**July 9, 2014
DRB Comments**

PROJECT # 1009785

APPLICATION # 14-70227

RE: Lots 5 - 12, Block 33, Raynolds Addition

**PLAT OF
LOTS 10-A, 11-A AND 12-A, BLOCK 33
RAYNOLDS ADDITION**

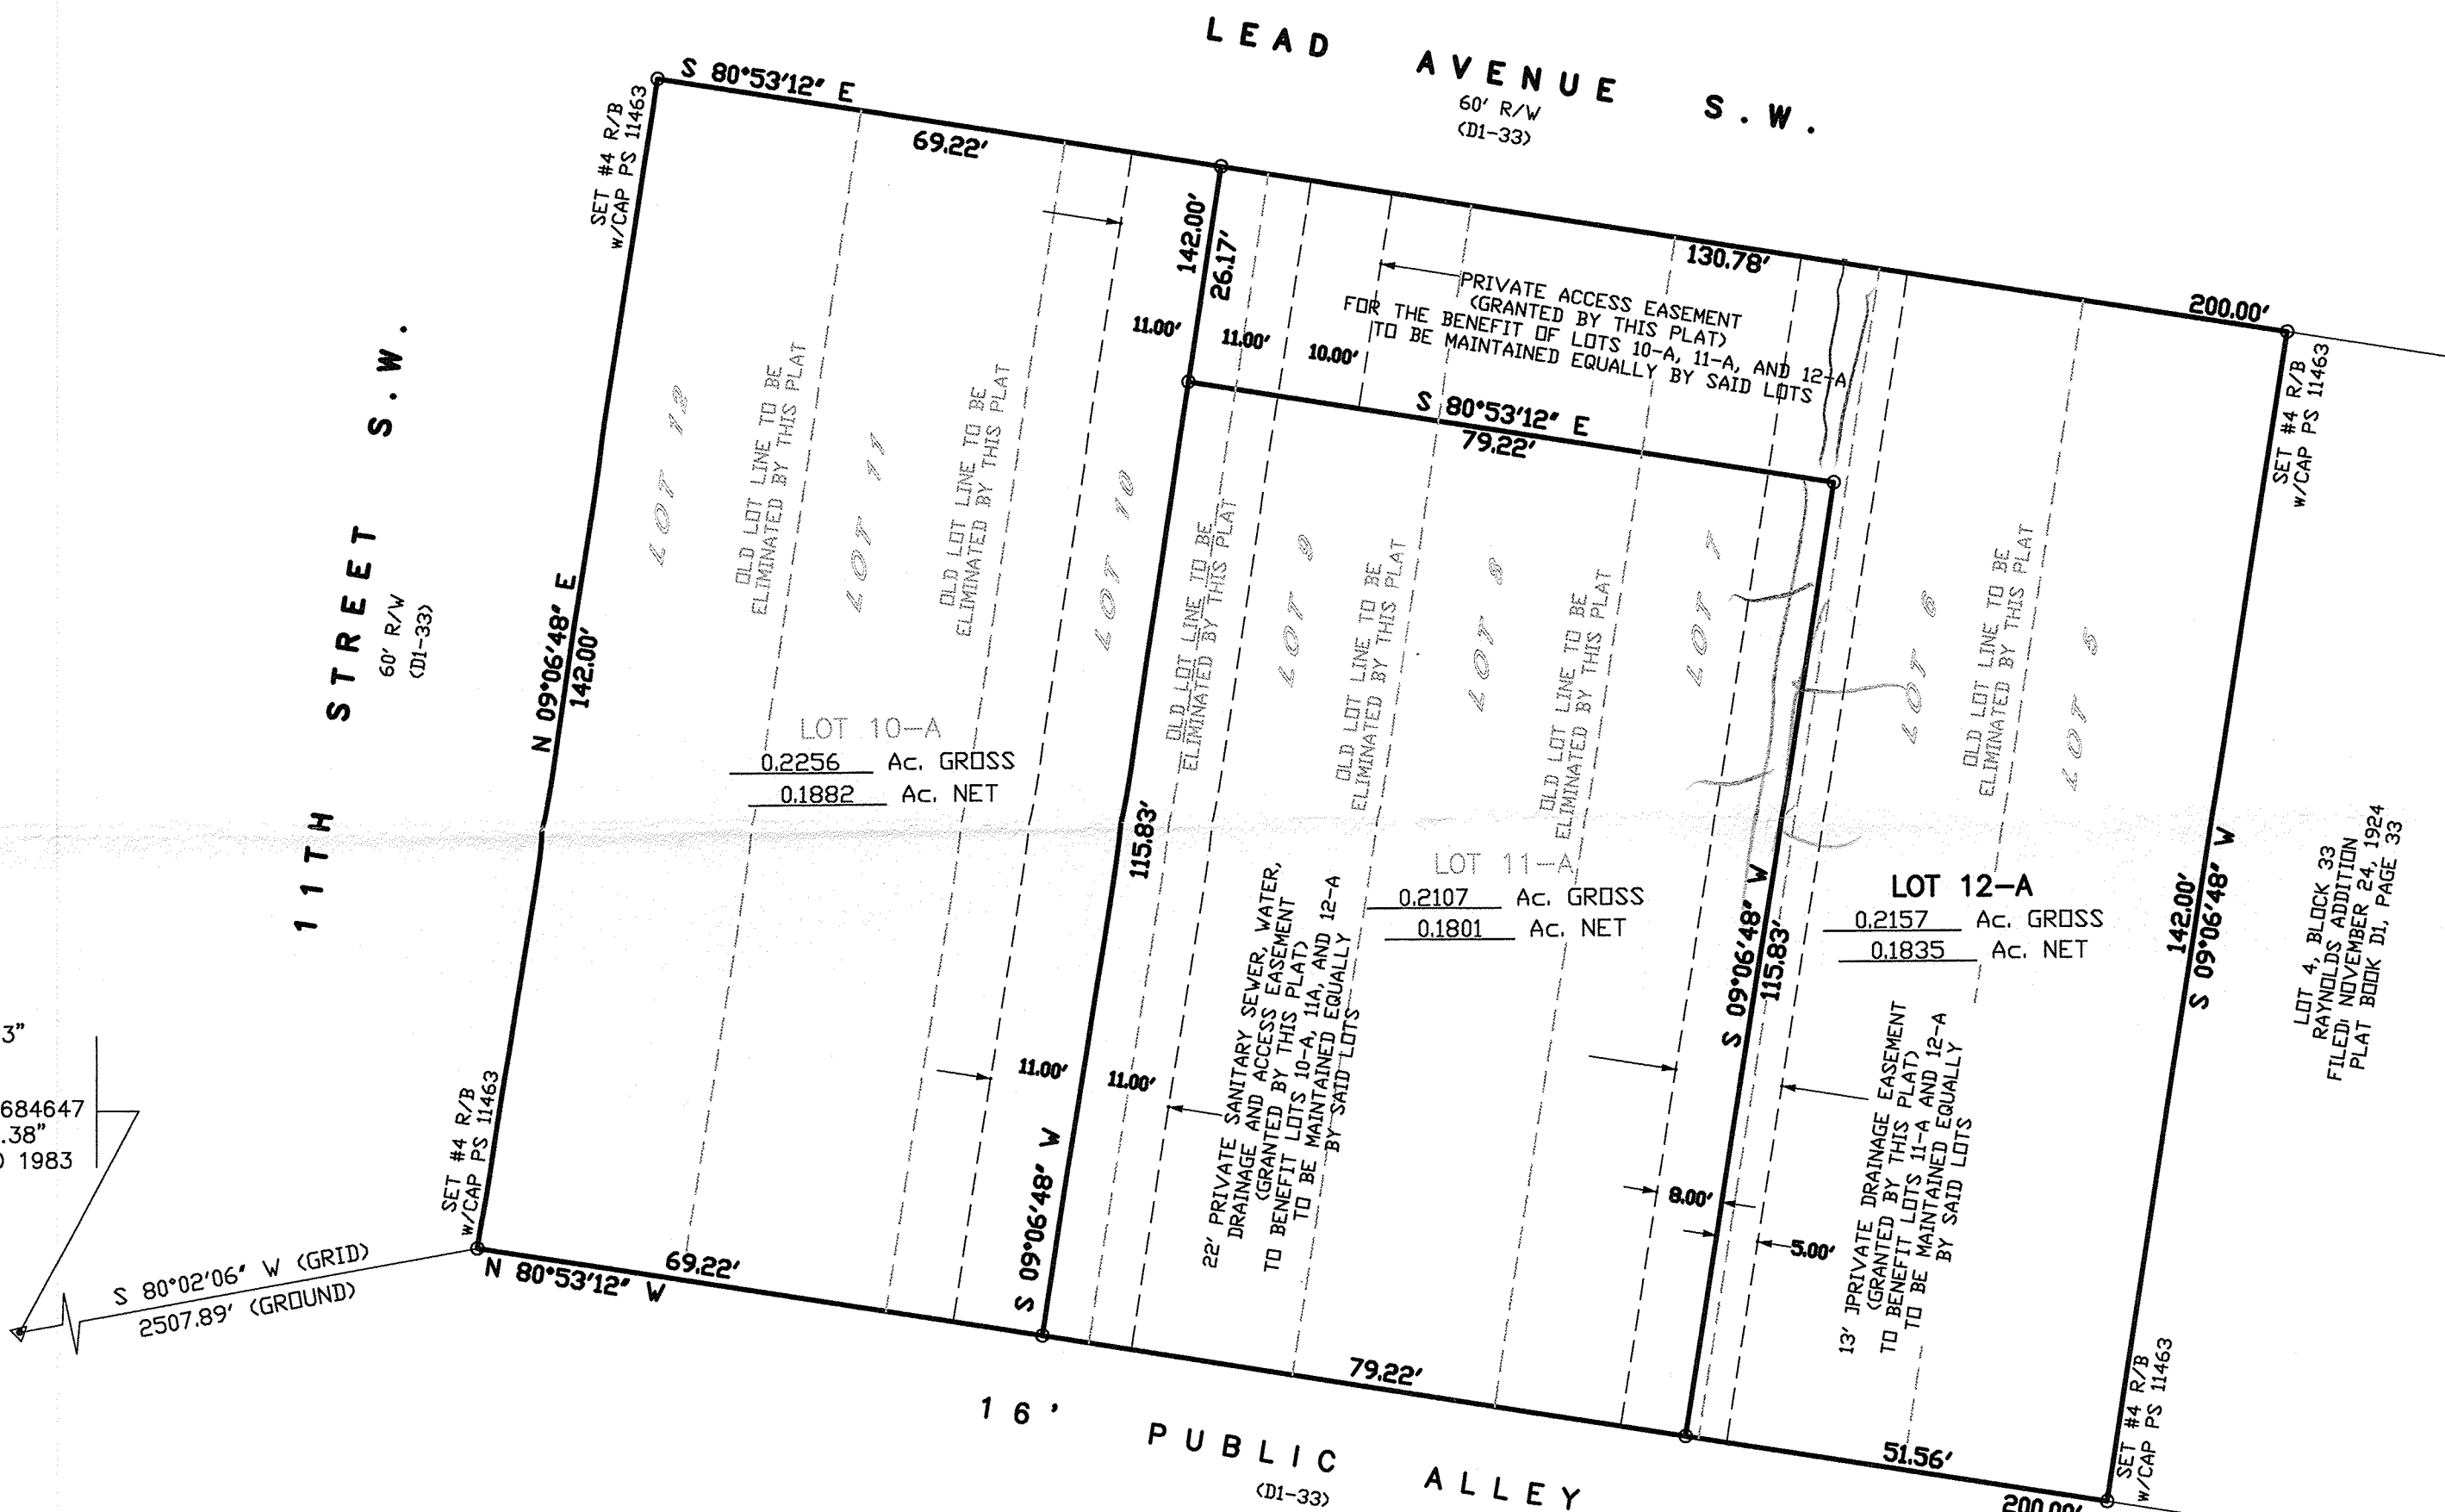
Site Development Plan approval by DRB is not required, however a site plan should be reviewed and verified by Zoning Enforcement prior to proceeding with plat, e.g. Huning Castle and Raynolds Addition Sector Plan calls for 400-600 sq ft of usable open space per unit depending on number of bedrooms (min 5,600 – 8,400 sq ft). The sector plan F.A.R. and parking requirements also apply; note on page 14, Item 3.a. that “Off-street parking shall be provided at the rear of property, with access from the alley.” The 24 ft Access Easement needs to be truncated short of the right of way for Lead Avenue.

A general comment regarding easements: they do not need to benefit the lots that they exclusively encumber, but rather they are meant to convey a property right to other lot owners (e.g. the 10' x 16' on 10-A, and the 4' on 11-A).

The 5' Private Pedestrian Access Easement appears to encumber Lot 11-A, therefore Lot 12-A should be a beneficiary.

It is not clear why the 20 ft Private Pedestrian and Vehicle Access Easement adjacent to the 24 ft Easement at Lead Ave is proposed to benefit Lot 10-A; this was shown as a driveway for garages on 12-A on the previous site plan.
